VICINITY MAP
1"=1000'

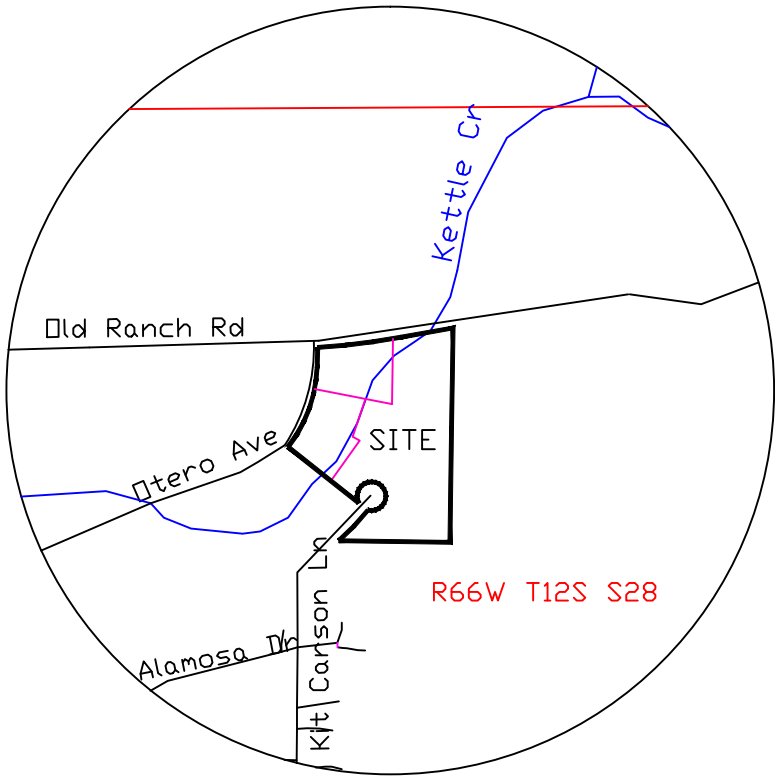
This map, as shown, would imply that the entire of Lots 7 and 8 are being proposed to be rezoned from RR-5 to RR-2.5. Please provide a legal description for the portions of the lots that are proposed to be rezoned - rezoning is done by legal description so the property to be rezoned needs to be described. I think it may be easier to conceptualize on paper if you do an "as existing" and "as proposed" so it's clear what portions of the property are being rezoned and include the legal descriptions of the areas proposed to be rezoned.

Please depict all existing easements.

Replace with "PCD File No. P-22-004".
